## Hearing Transcript

<b>Project:</b>	A46 Newark Bypass
<b>Hearing:</b>	Issue Specific Hearing 4 (ISH4) - Session 1
<b>Date:</b>	05 December 2024

# AUDIO\_A46\_ISH4\_SESSION1\_2024-12-05

DRAWING NUMBER HE551478	ORIGINATOR SKAG	VOLUME EBD	PROJECT REF NO. HE551478
LOCATION CONWI_CONW	TYPE DR	ROLE LE	REVISION C01
	NUMBER 00171

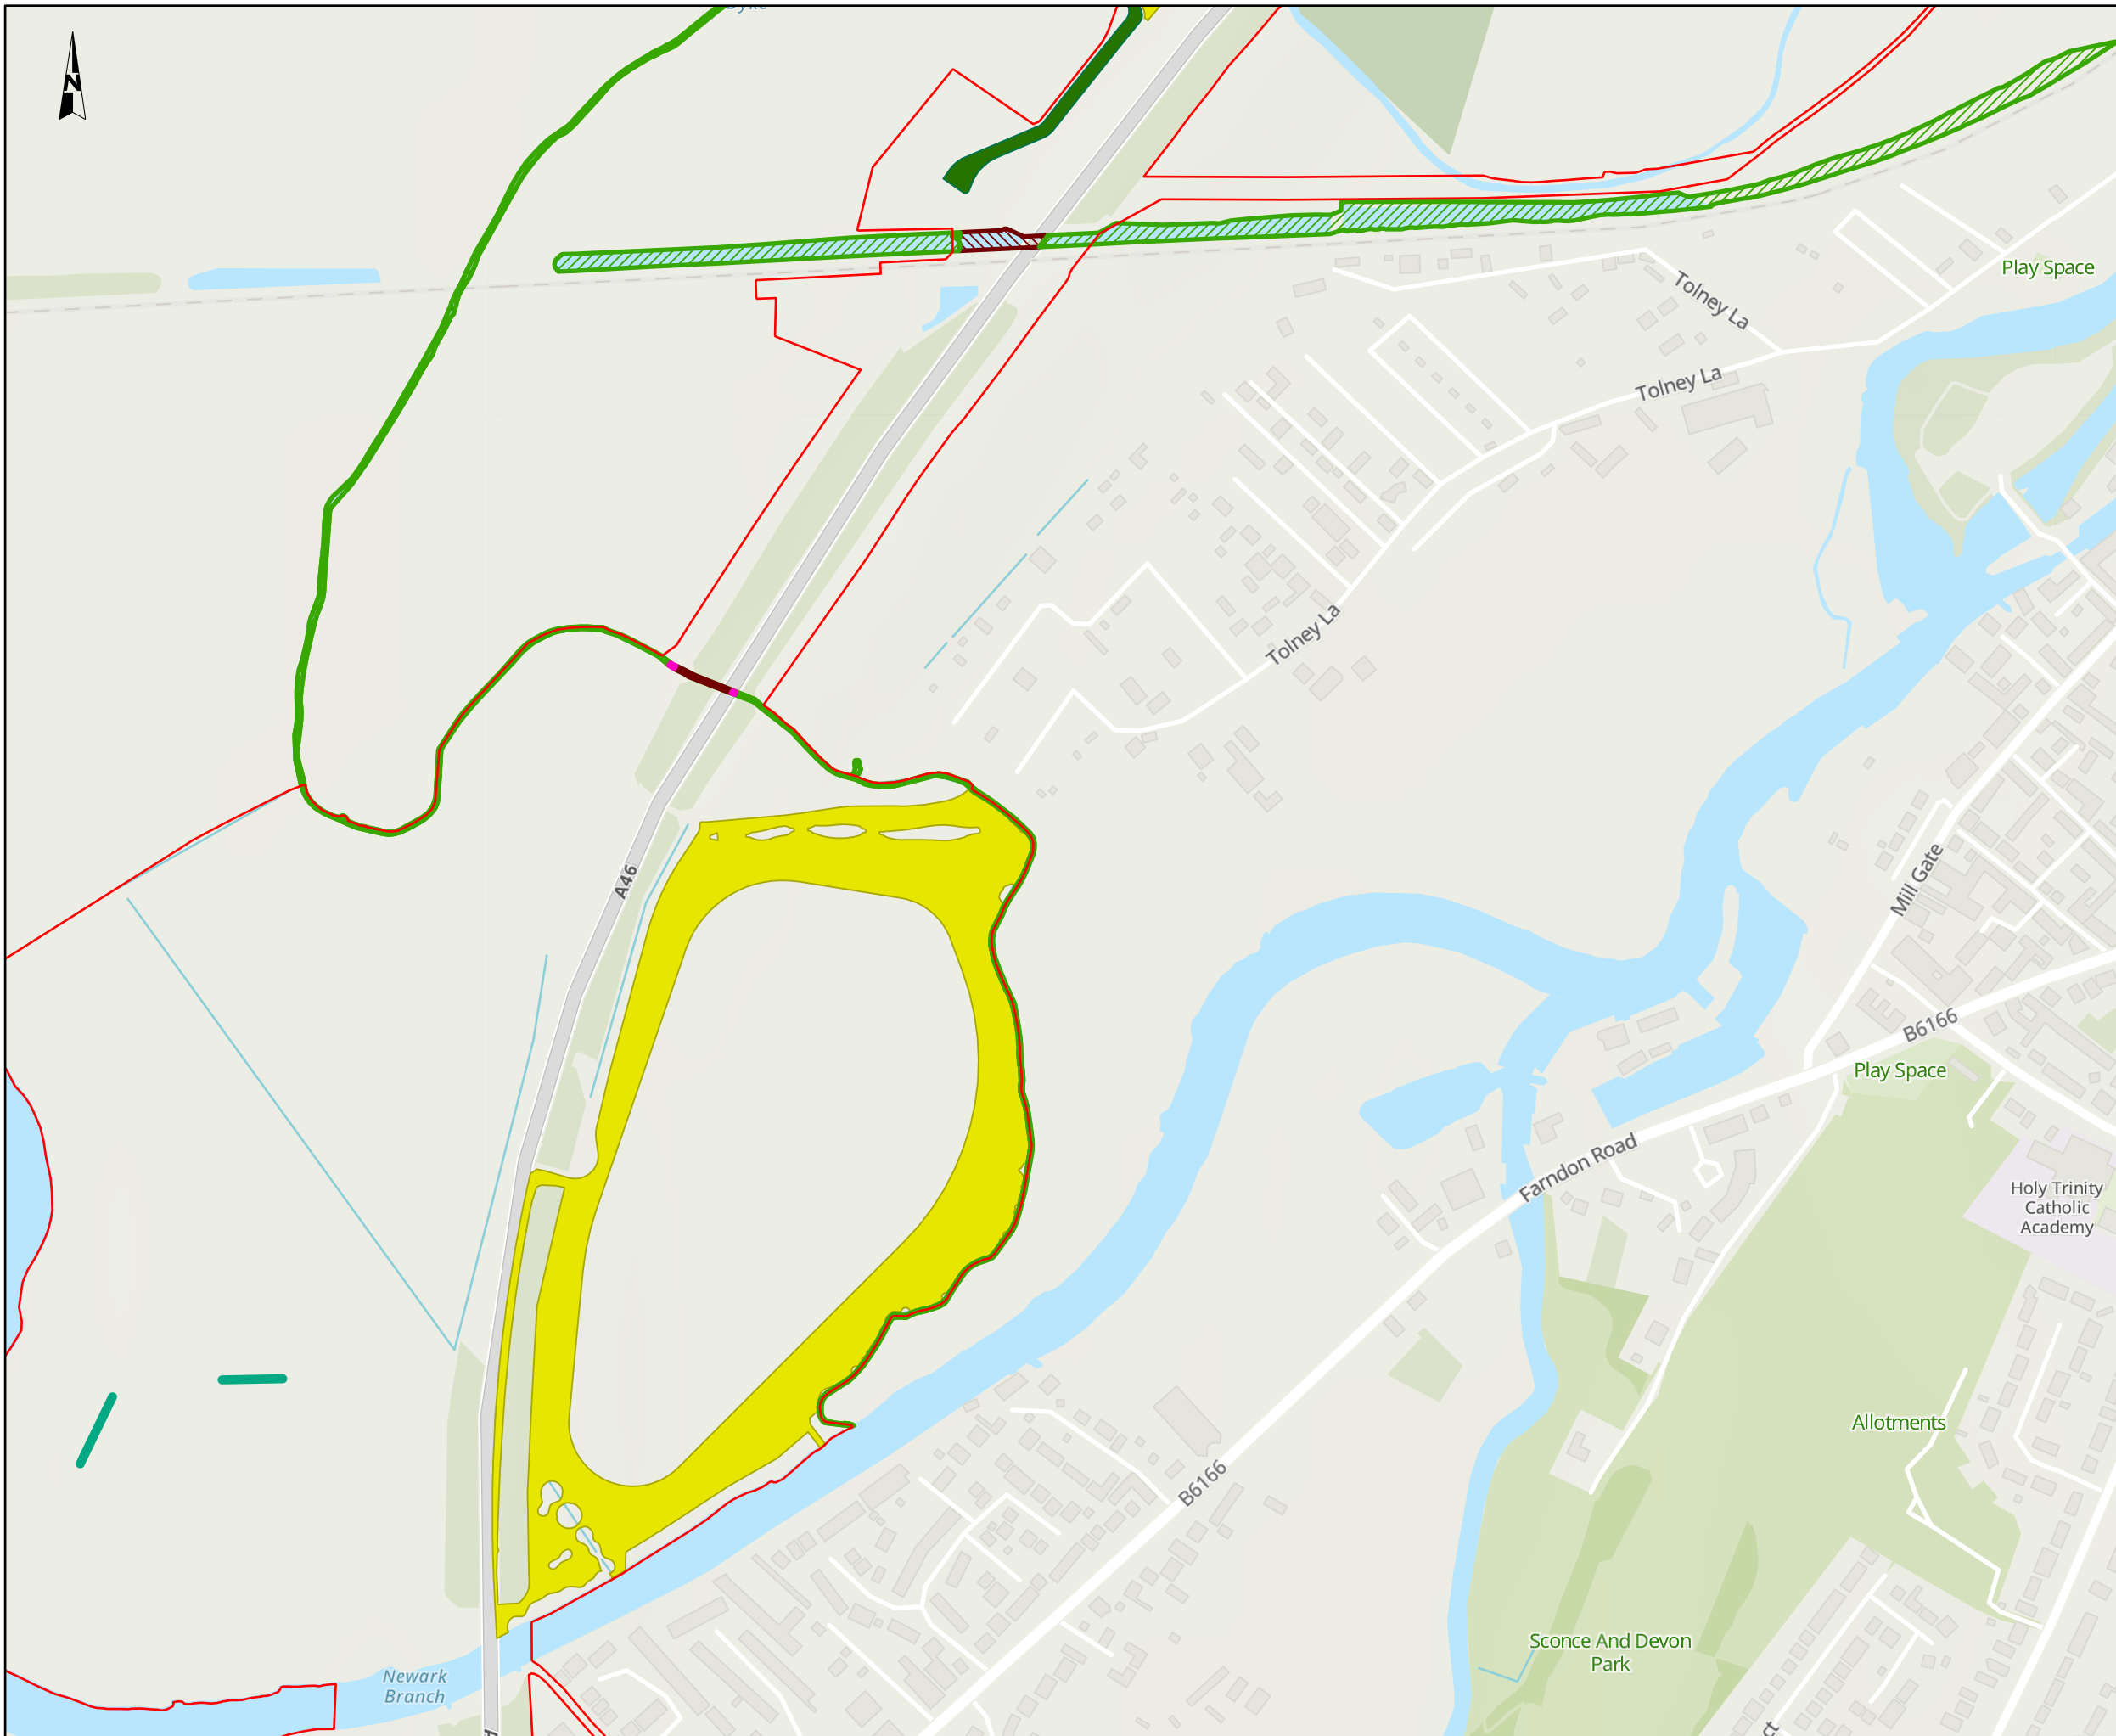
you. Right. I just want to move on. Then. Can we turn to document as 045, it's titled figure 8.4 compensation planting for loss of local wildlife site habitats. And I'm just going to, I'll just give the applicants an opportunity to bring this on screen.

Thank you very much. Can we turn to the last page? Please? It's PDF page four of four.

Perfect. Thank you very much. Okay, we may want to just scroll to the sort of top of that. That figure. There we are, brilliant. Can you talk me through those areas of temporary loss on this page, please, because it might be, it might be just, I'm not seeing it, but I don't. I see areas of retention which are outside the order limits and but I don't, and I see areas of permanent loss. I'm not seeing any areas of temporary loss on this page. Am I just missing it? Or you just talk me through, please.

This is Vicky Coulthard on behalf of the applicant. So we're referring to dairy farm, railway strip, Newark, local wildlife site. You

Okay, yes. So this is Vicki cauldron on behalf of the applicant. So that refers to old Trent dyke local wildlife site.

No, that's, that's the only area temporary, temporary loss.
